Our Ref: L10002217
20 August 2026

**Arrangements for Handling Heritage Applications Direction 2021 & T&CP
(Development Management Procedure) (England) Order 2015 & Planning (Listed
Buildings & Conservation Areas) Regulations 1990**

George Hotel, St George's Square, Huddersfield, HD1 1JA
Application No. 2026/70LBC/91801/W

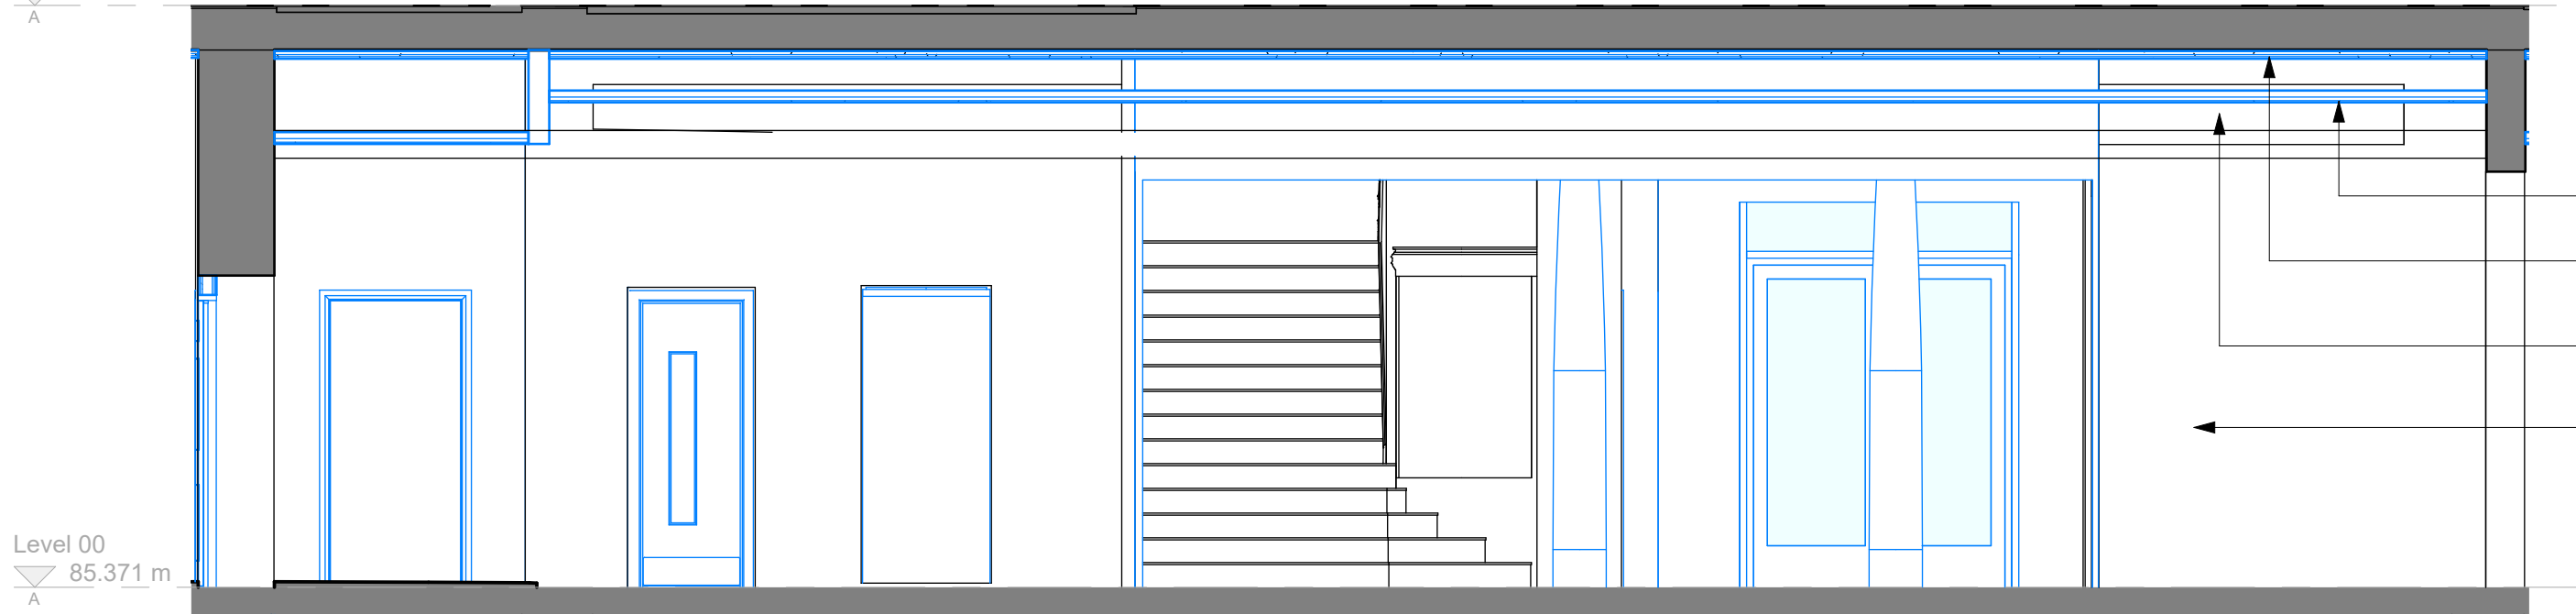
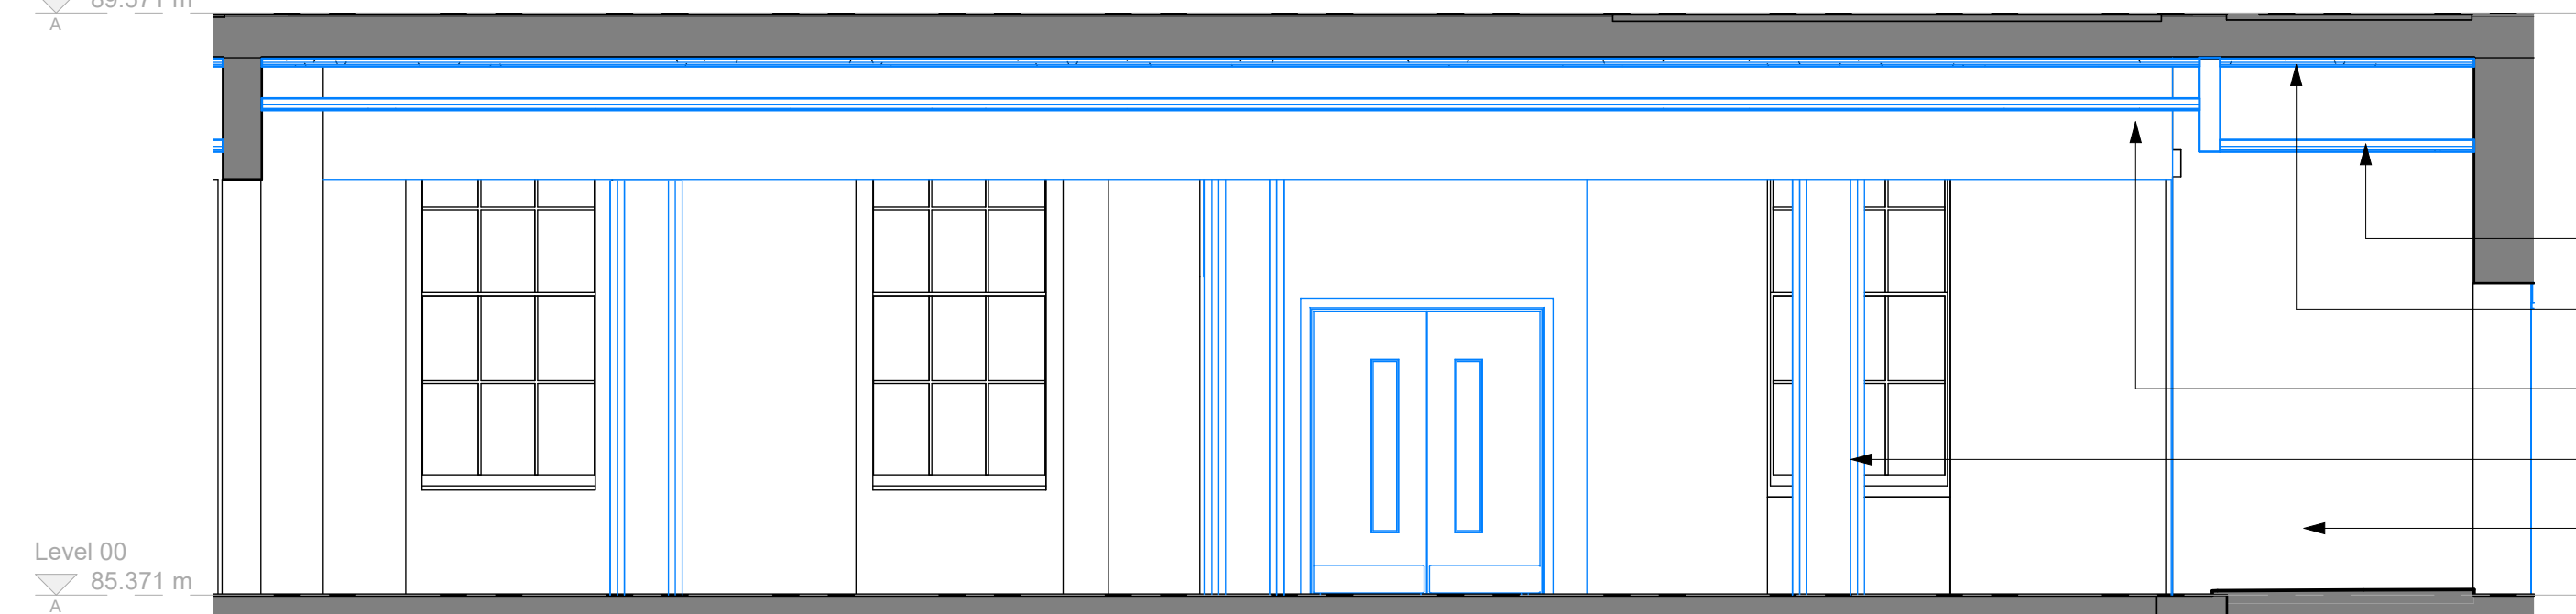
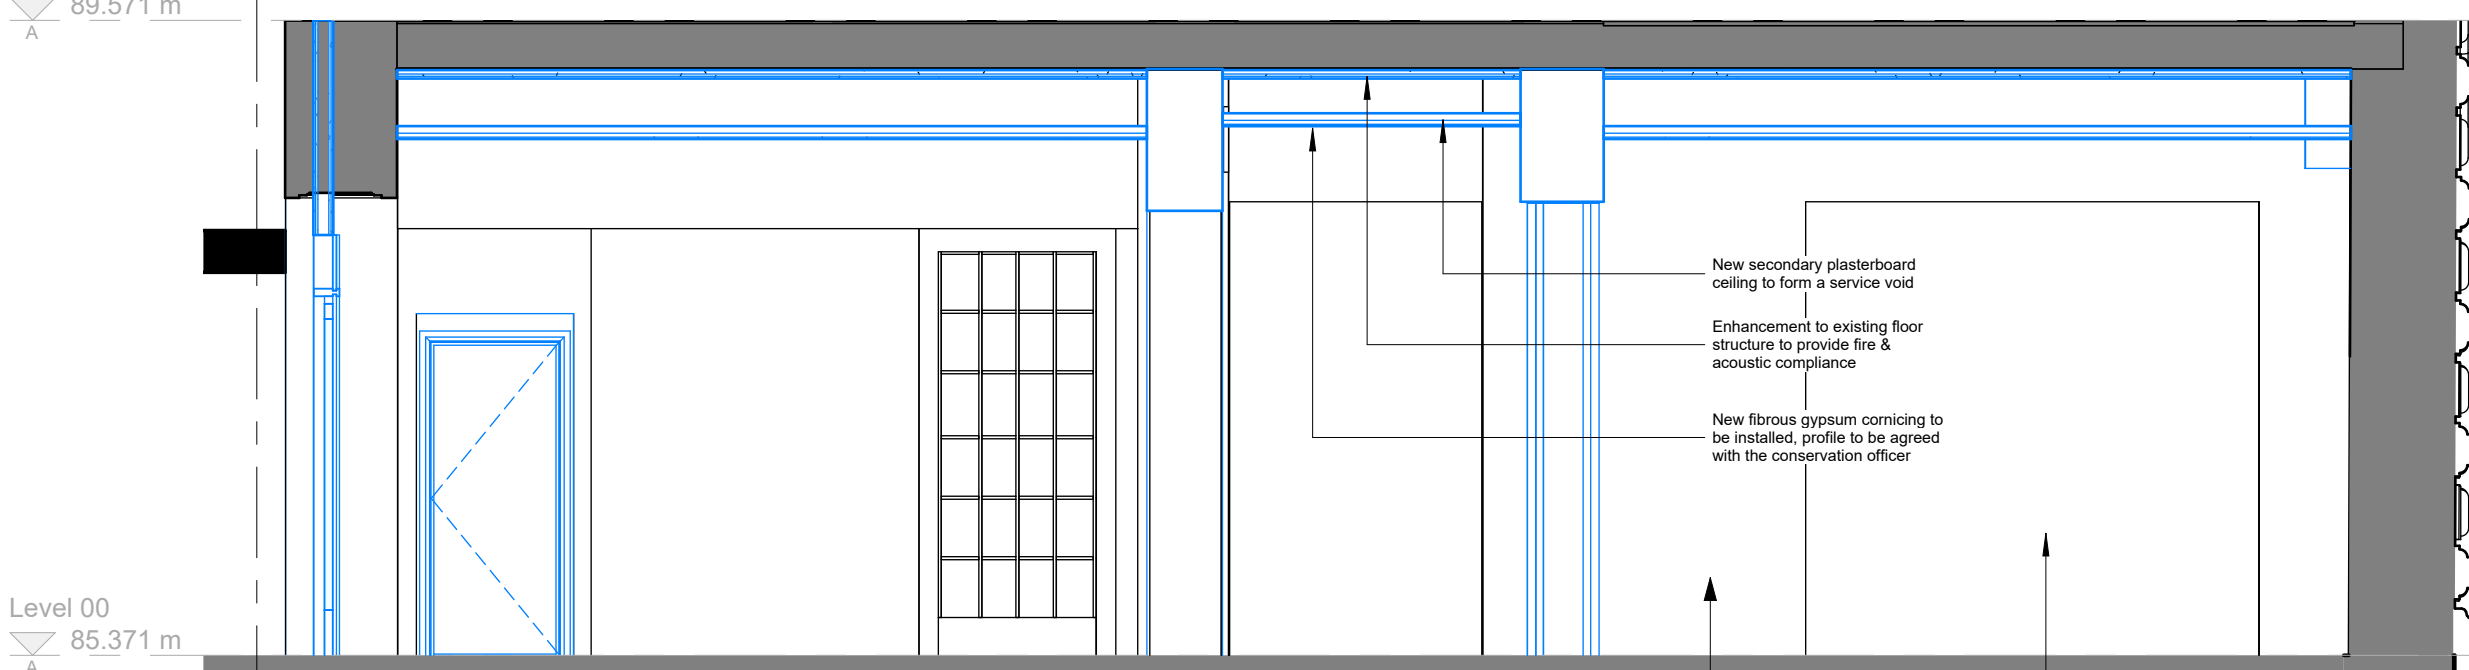
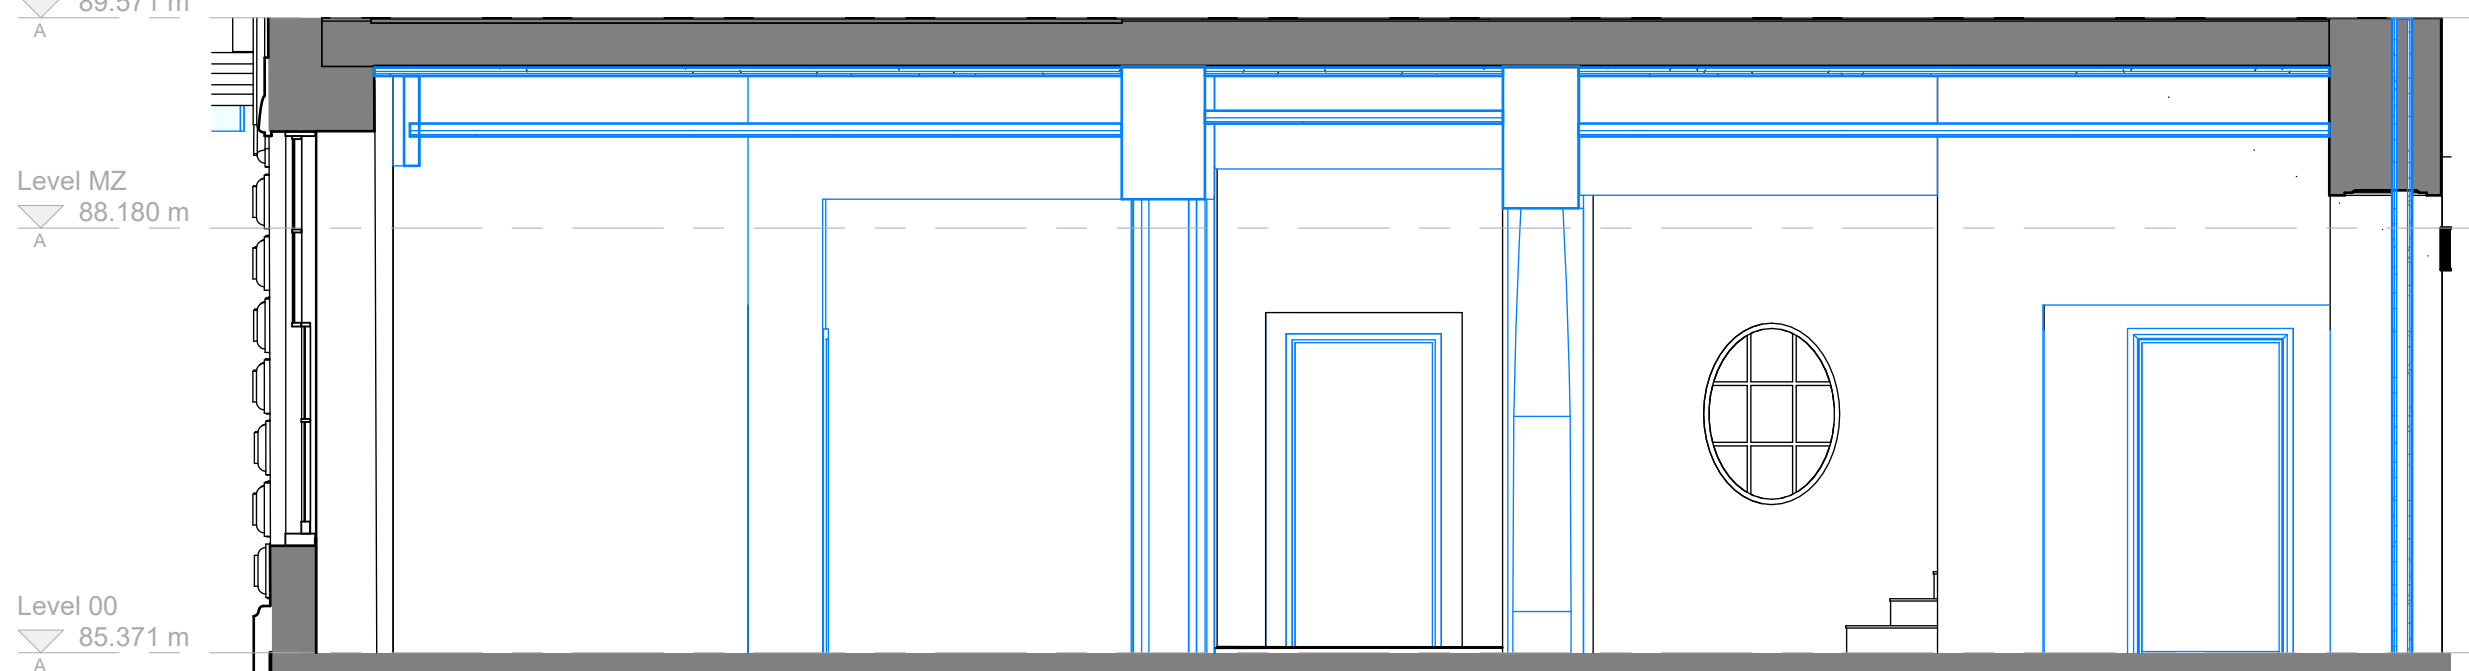
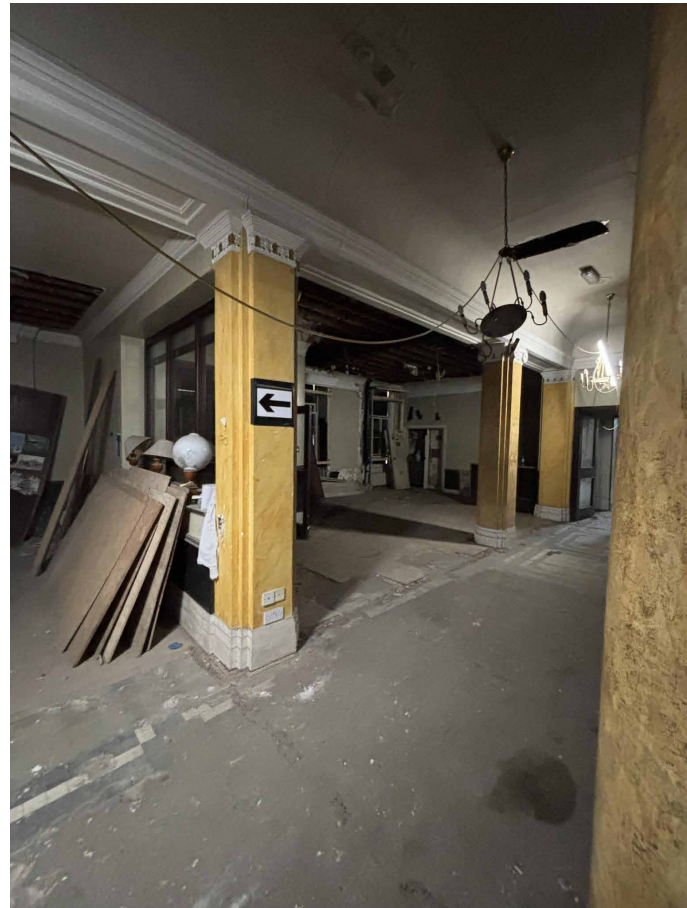
- The revised proposals will result in an increased loss of historic fabric, including features such as skirtings, doors, cornices and ceiling roses. Consideration should be given to alternative measures to allow retention of architectural features, whilst meeting the needs of the hotel. Historic England guidance is available online, such as Fire Resistance and Historic Timber Panel Doors:
<https://historicengland.org.uk/images-books/publications/fire-resistance-historic-timber-panel-doors/ife-sig-guide-fire-resistance-historic-timber-panel-doors/>.
